Permit Reviews

Permit Number: **BCOM2604-0008**

Description: **Coats Downtown Square (Anchored Shade Sails)**

**DRAWING DESCRIPTION:**  
**FOOTING DETAILS**

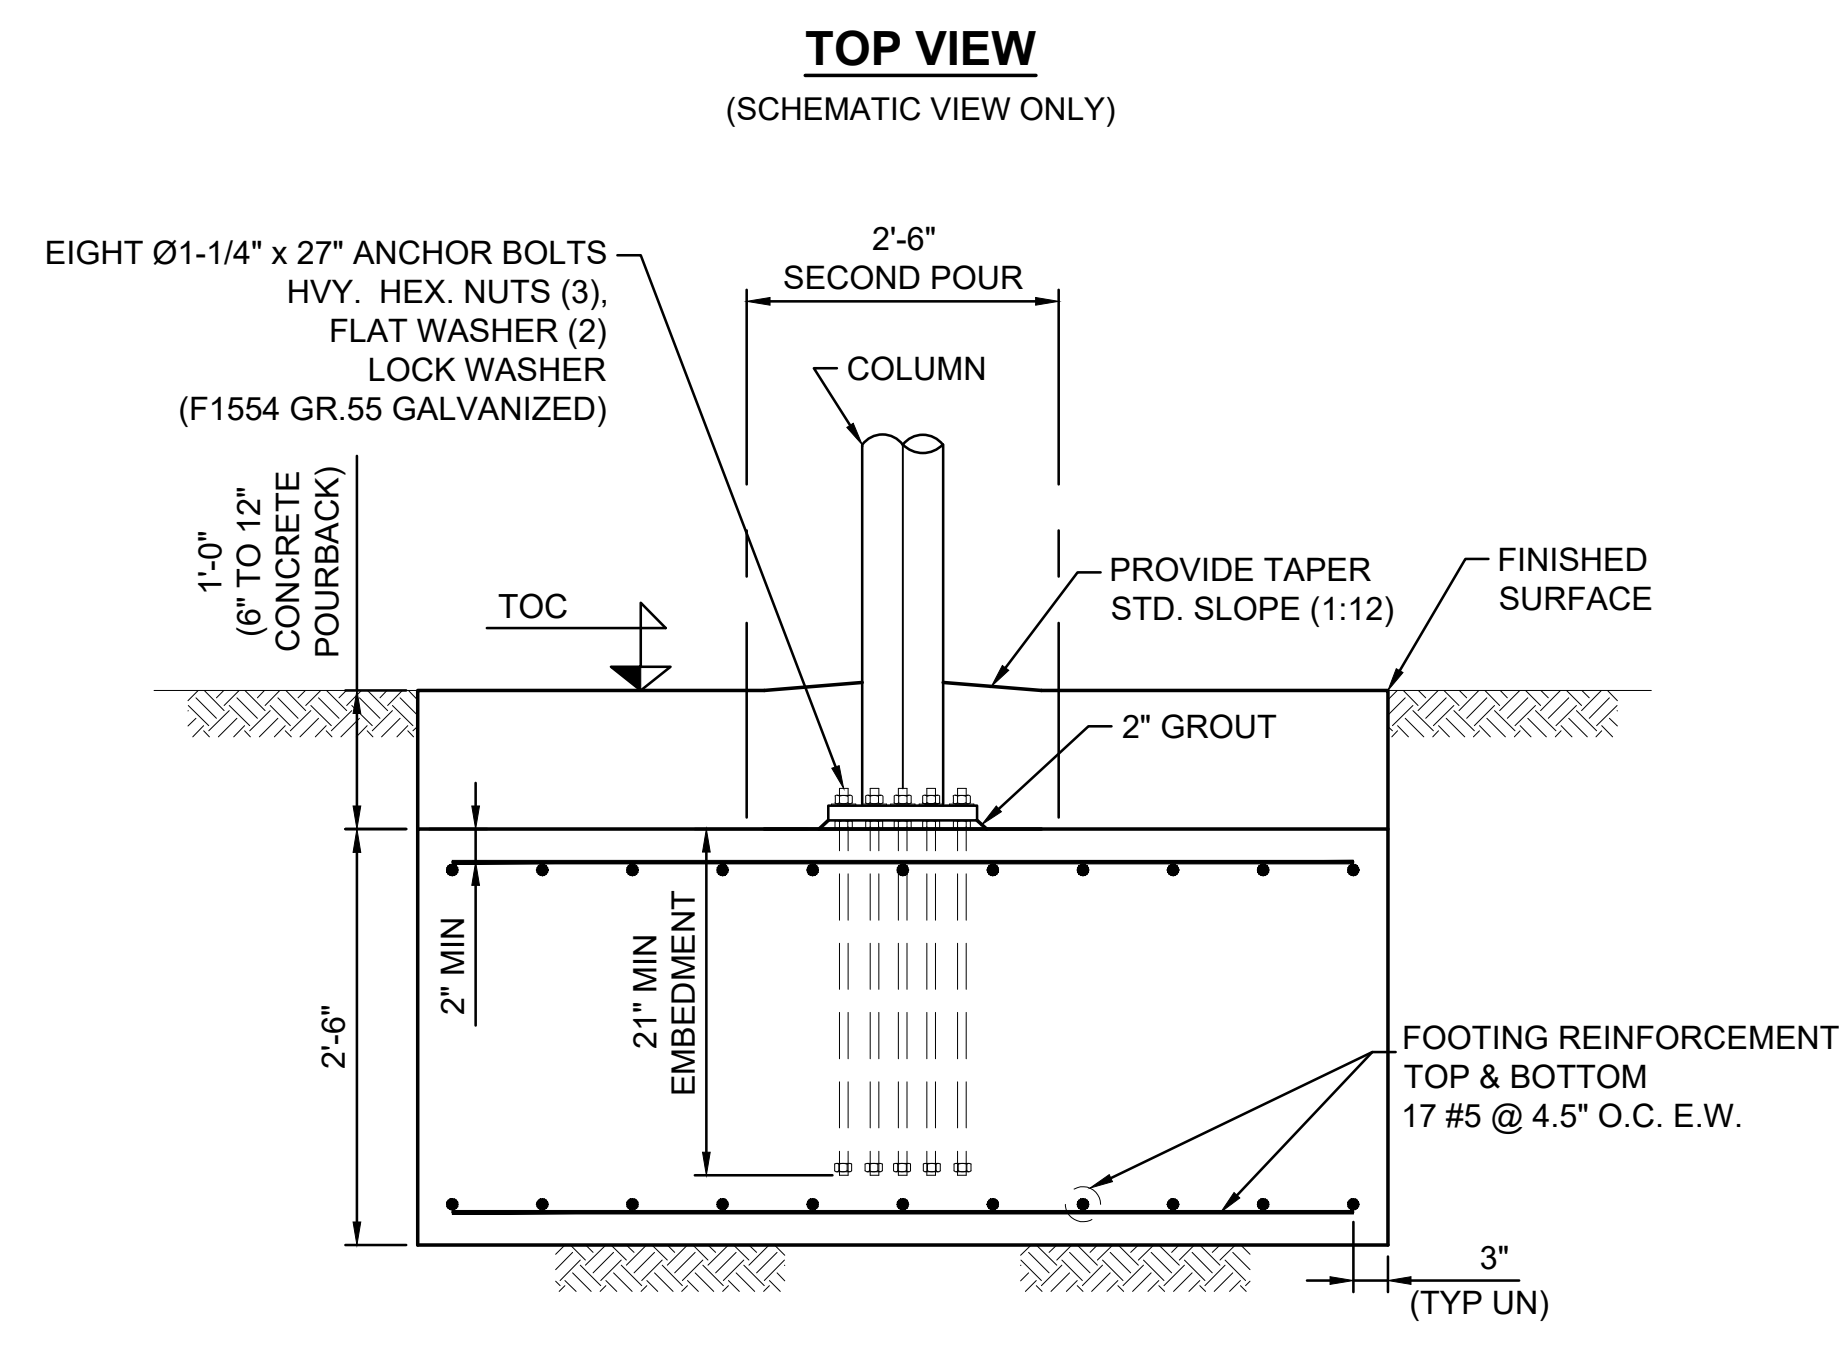
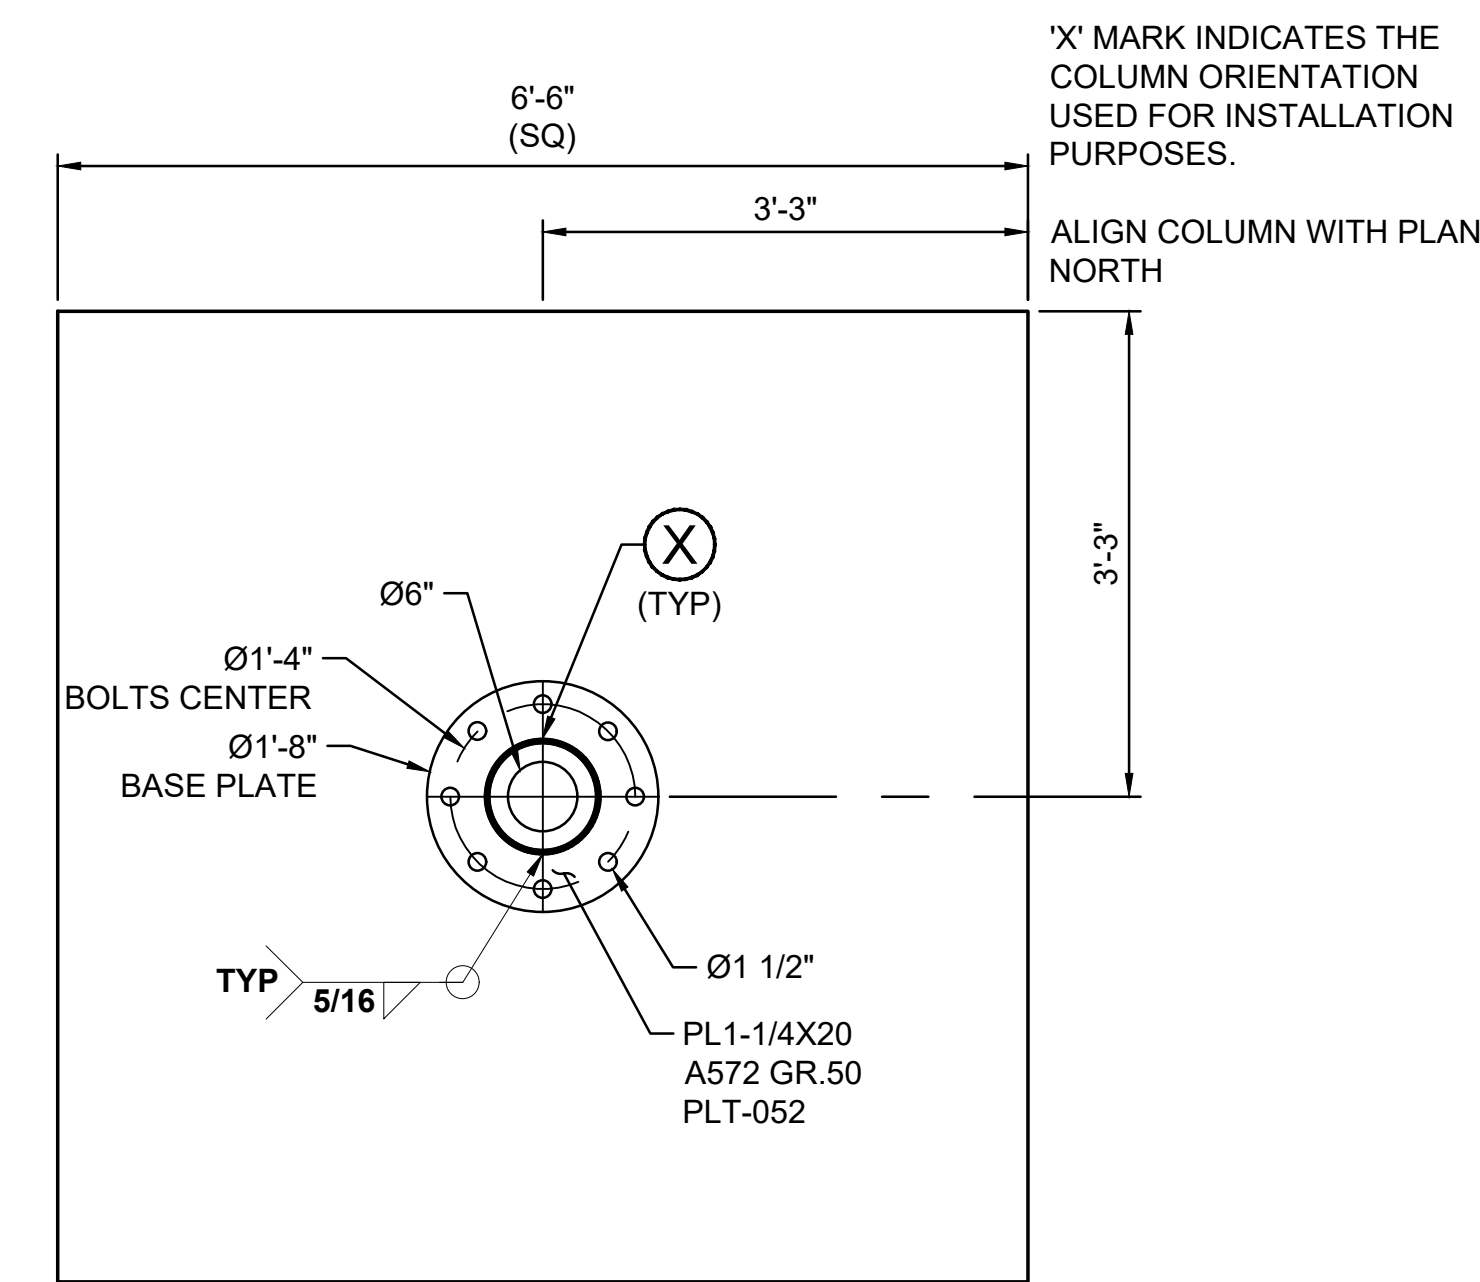
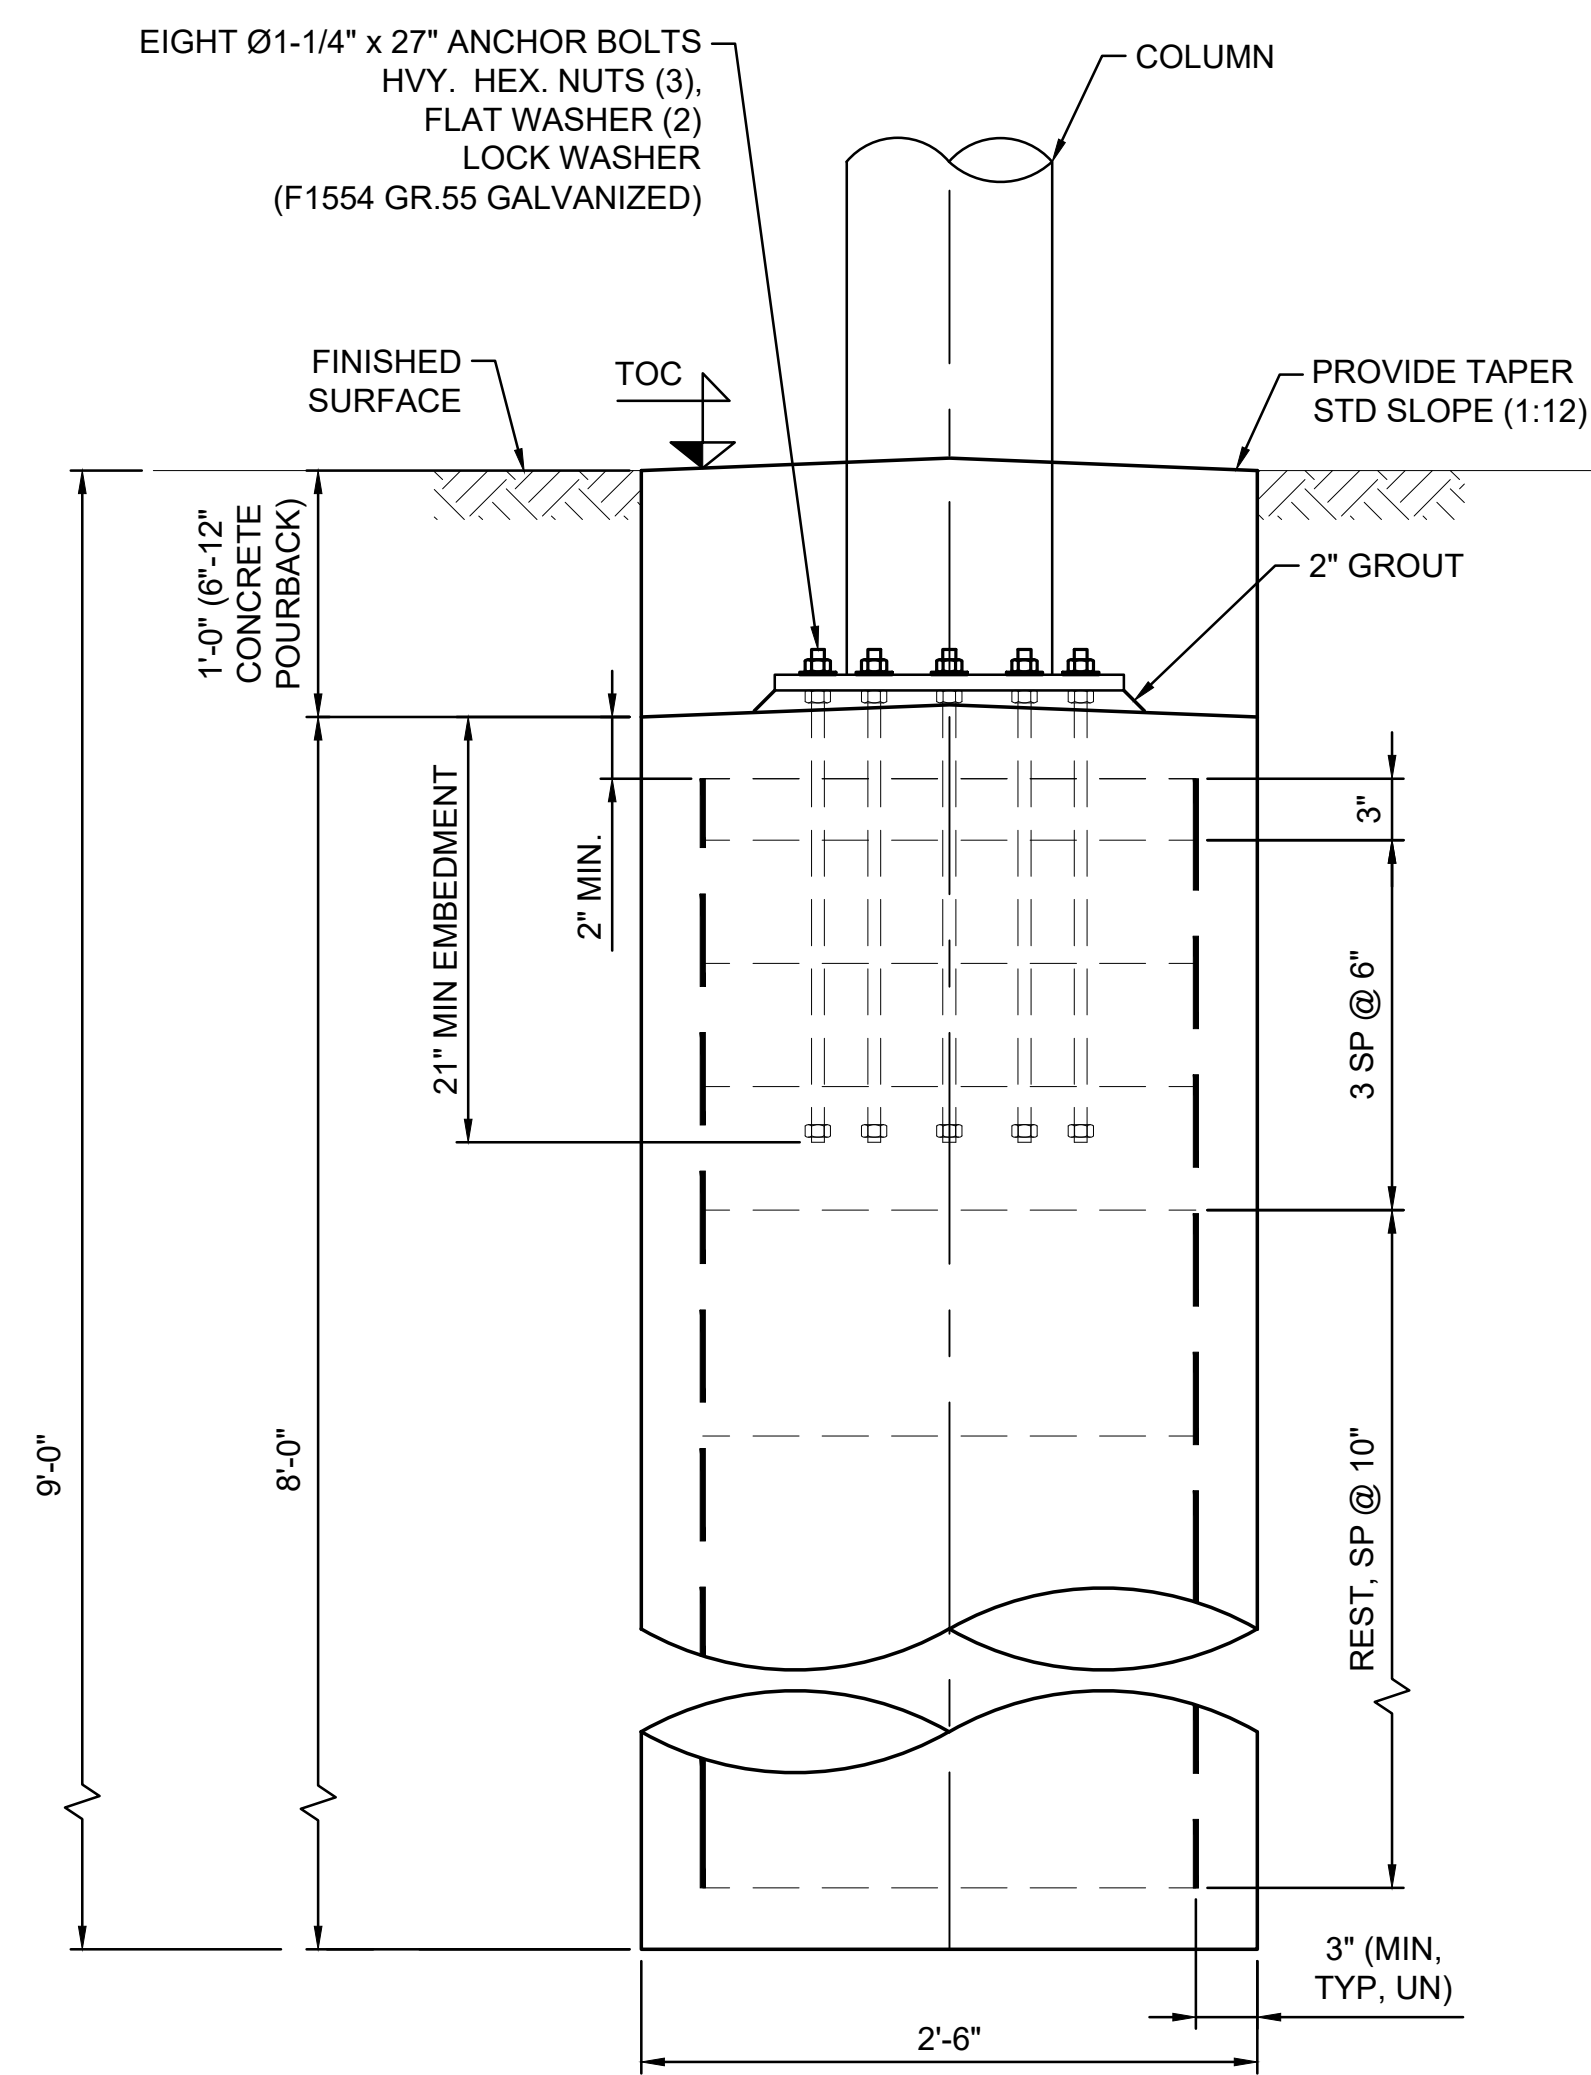
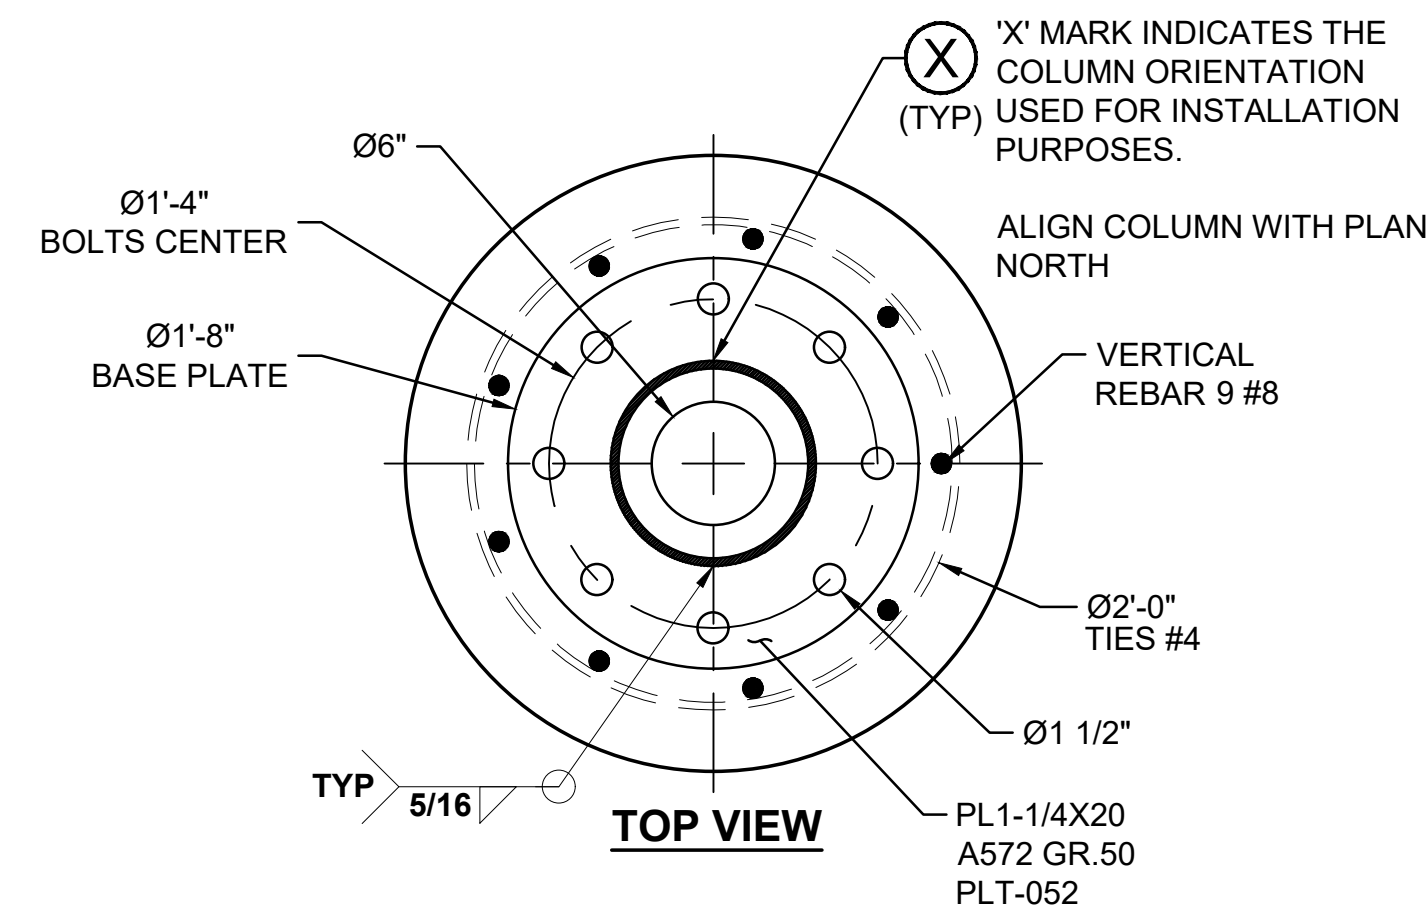
SENT DATE	RETURNED DATE	DUE DATE	TYPE	CONTACT	STATUS	REMARKS
Review Group: AUTO						
4/14/2026	4/15/2026		COMMERCIAL INTAKE	CP Bucket	APPROVED	
Notes:						
4/14/2026	4/16/2026	4/28/2026	COMMERCIAL BUILDING REVIEW	Brad Sutton	DISAPPROVED	
Notes:						
Need structural details for sail shade/festoon lighting supports. Footings and post info						
4/14/2026		4/28/2026	FIRE MARSHAL	Fire Bucket		
Notes:						
4/16/2026			COMMERCIAL BUILDING REVIEW	Building Bucket		
Notes:
